JMT Consulting
PO Box 199
Kingsford NSW 2032
0415 563 177
www.jmtconsulting.com.au

18 December 2025

This Response to Submission Statement relates to the transport impact assessment report. It is submitted to the Department of Planning, Housing and Infrastructure (DPHI) in support of the Response to Submissions (RTS) to the State Significant Development Application (SSDA) (SSD-82548708) for a residential flat building with infill affordable housing at 24, 26 and 28 Middle Harbour Road, Lindfield.

BASEMENT 2
1:400

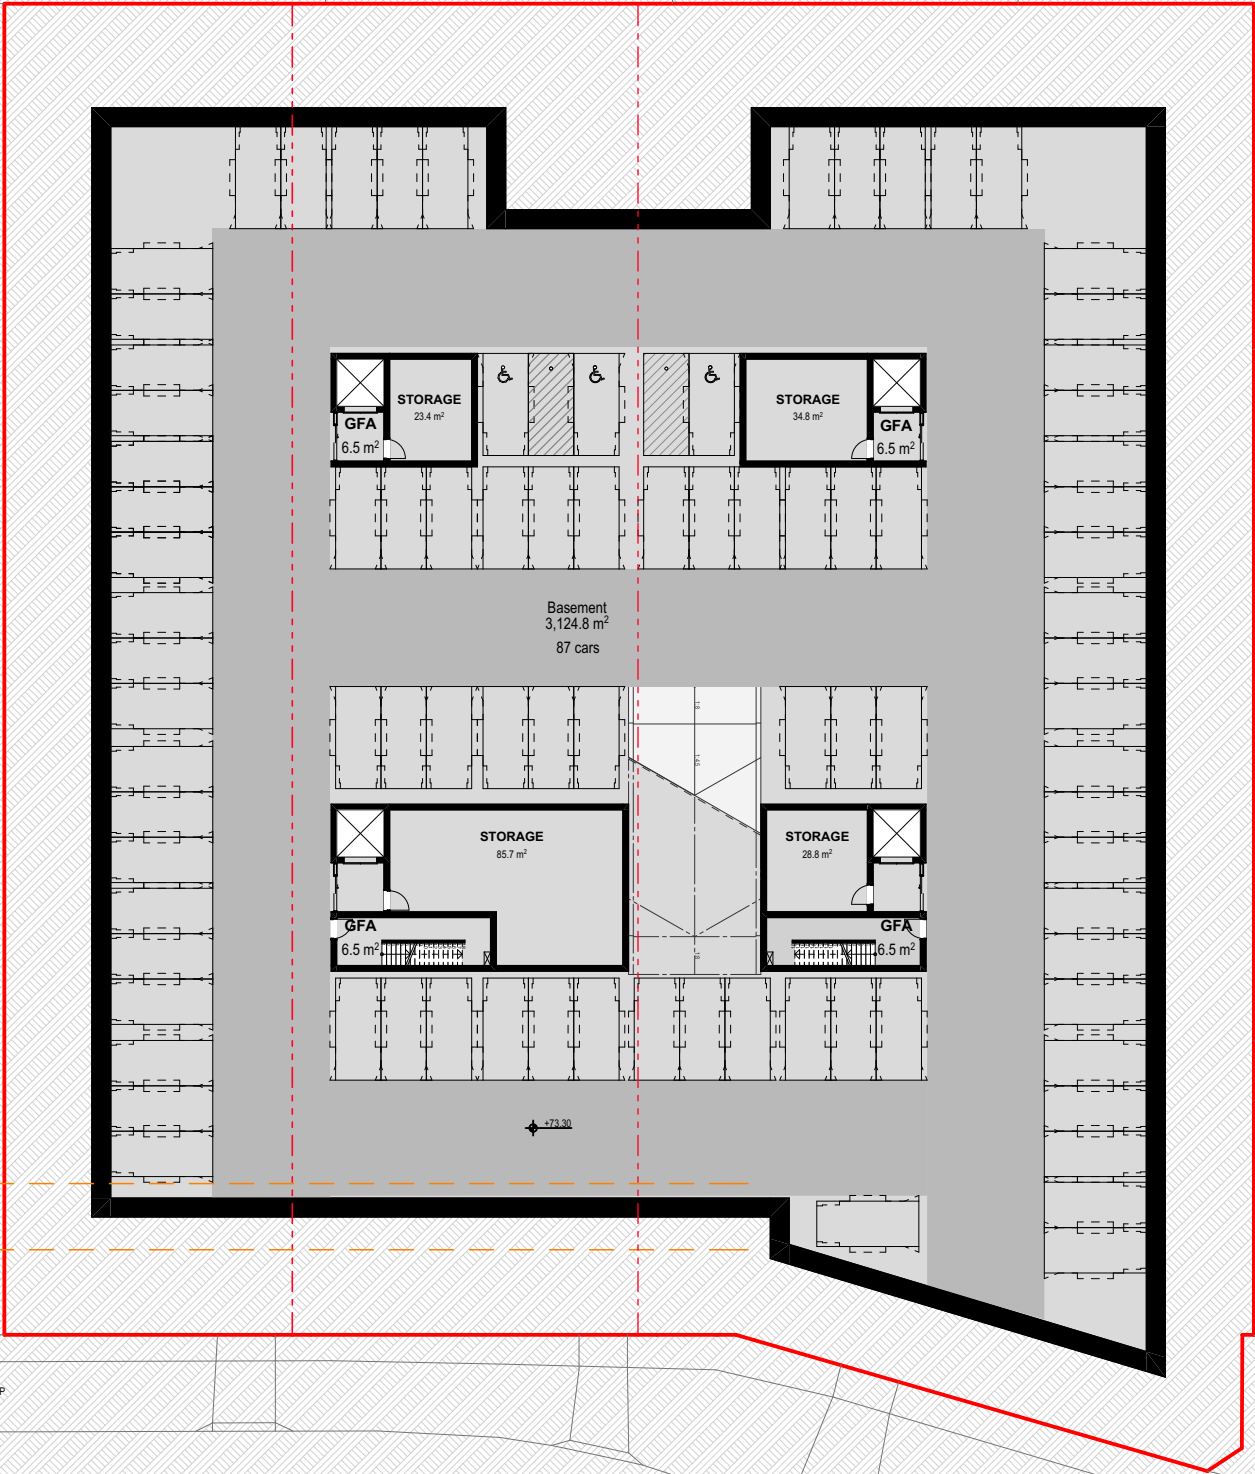
The swept path analysis indicates that Medium Rigid Vehicle (MRV) movements are likely to result in conflicts / overlap to the two-way movement of vehicles within the basement entrance ramp. Redesign the basement layout / access to address this issue or justify how these conflicts and potential safety implications can be ameliorated.

Agency	Agency Comment	JMT Consulting Response
DPHI	Update the basement layout plans to annotate the location of visitor, accessible and car-share parking spaces	Basement plans have been updated as requested by DPHI
DPHI	Amend the design and layout of the basement vehicle driveway, access ramp and loading dock to accommodate a minimum 6.7m long service vehicle.	The design has been amended to accommodate Council's 6.7m long waste truck, refer to swept paths in Figure 3 below  Figure 3 Swept paths – 6.7m Council waste truck
DPHI	The EIS repeatedly refers to the provision of 'ambulance and mini-bus' parking at basement level (e.g. EIS p58 and p116). Confirm whether this is proposed	This was an error in the EIS, no ambulance or minibus parking is proposed as part of the development

The amended basement design provides for simultaneous passing of a B99 vehicle and a B85 vehicle at all times as required under AS2980.1. This is shown in Figure 1 below.

There is no Australian Standard requirement that ramps in residential developments, where the instances of heavy vehicle movements are very low, must accommodate simultaneous passing of heavy and light vehicles at all times.

As shown in Figure 2 passing of a passenger vehicle and a Council waste collection truck is possible along the vast majority of the path of travel, with just a small section of overlap – refer to Figure 2. Importantly these vehicles can pass each other at the top of the ramp at street level.

Agency	Agency Comment	JMT Consulting Response
		 <i>Figure 2 Swept paths – car passing waste collection vehicle</i> Typically situations such as these are addressed through signage and the provision of mirrors so vehicles can sight one another as they are travelling through the car park at all times. Although heavy vehicle movements will be very low, to address the submission stop lines and mirrors can be introduced at the corner of the south-western area of the basement to mitigate any concerns around vehicle conflicts. Signage would also be introduced to make drivers aware of potential oncoming traffic movements.
